Review Response

Project Name: Seda Pier

Response To: Impervious Calculations Correction

This letter is in response to the corrections SHL23-015 and SEP23-004. Below are our responses to the questions/comments from 07/25/2023.

# HARDSCAPE CALCULATION DRAWING - EXISTING

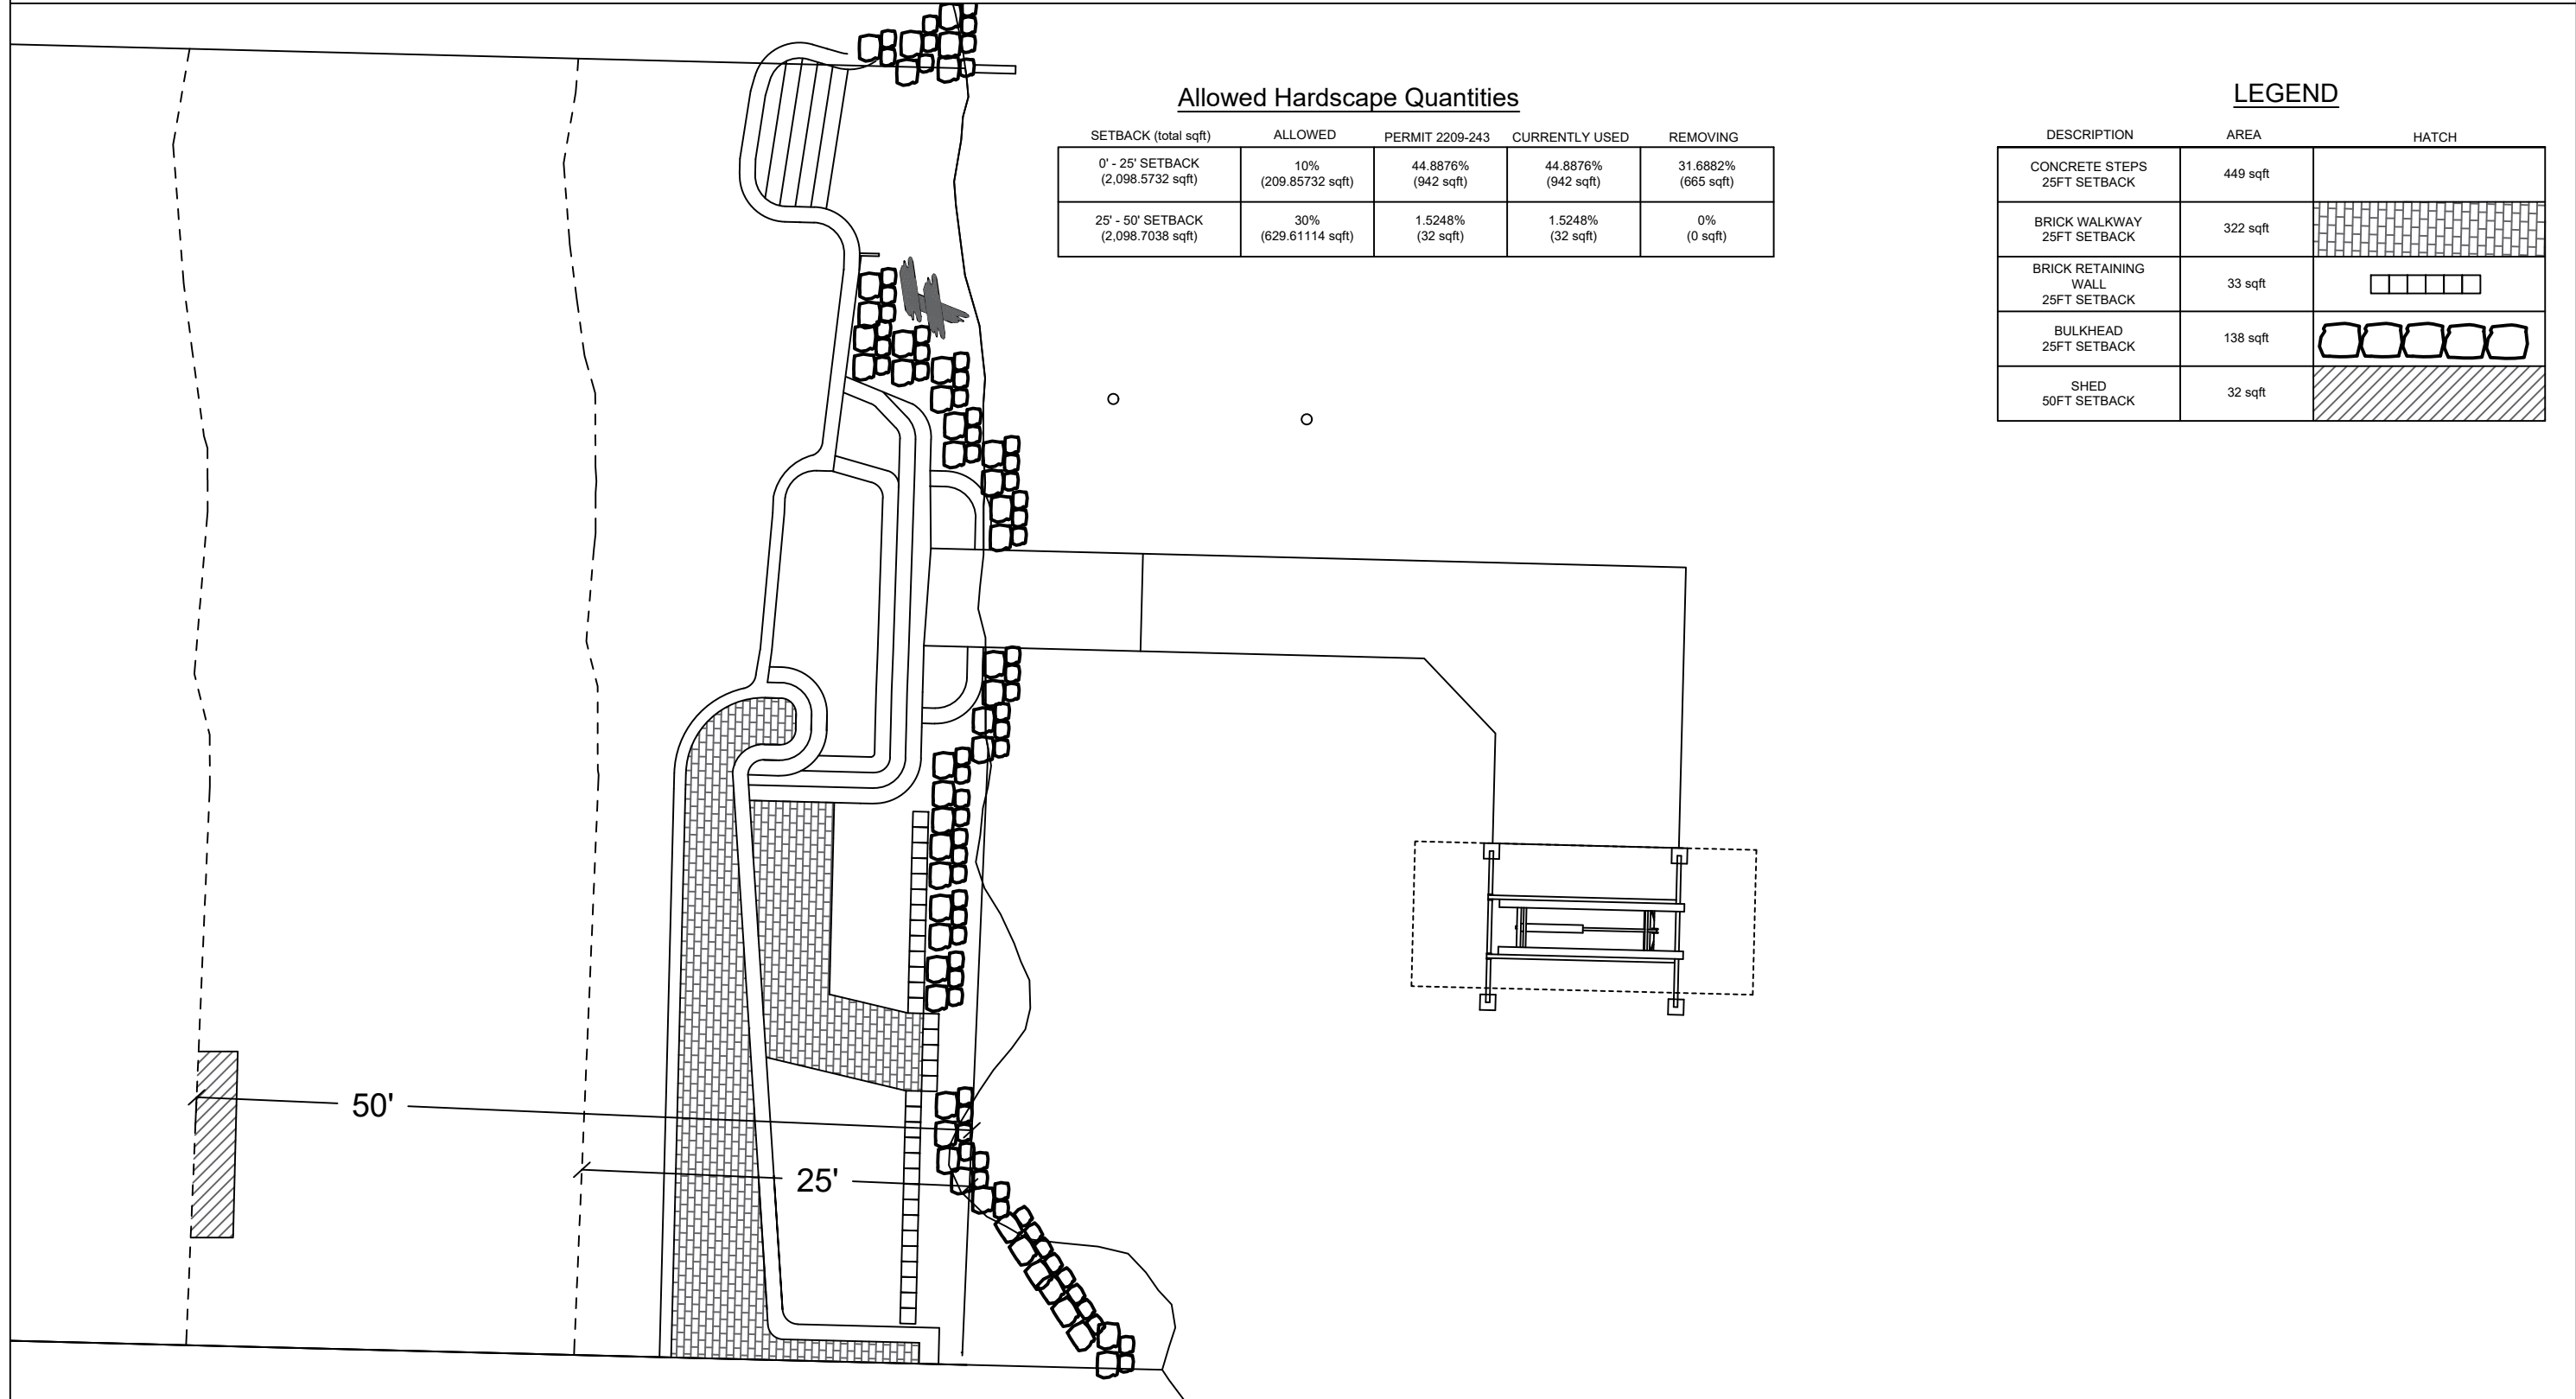
1. Plan set updated for consistency.
2. The existing 942 sqft of hardscape is permitted under 2209-243, and is therefore legally nonconforming. Under MICC 19.13.020.A legally nonconforming structure may be repaired, and completely replaced which is in line with our proposal. We are proposing to make it more conforming by working with the client to voluntarily remove 665 sqft of the permitted hardscape, reduce the impact, while repairing some of the areas and enhancing the cove area. We have letters from HPA and Ecology advocating for the benefits of enhancing the cove that I can send if you would like.
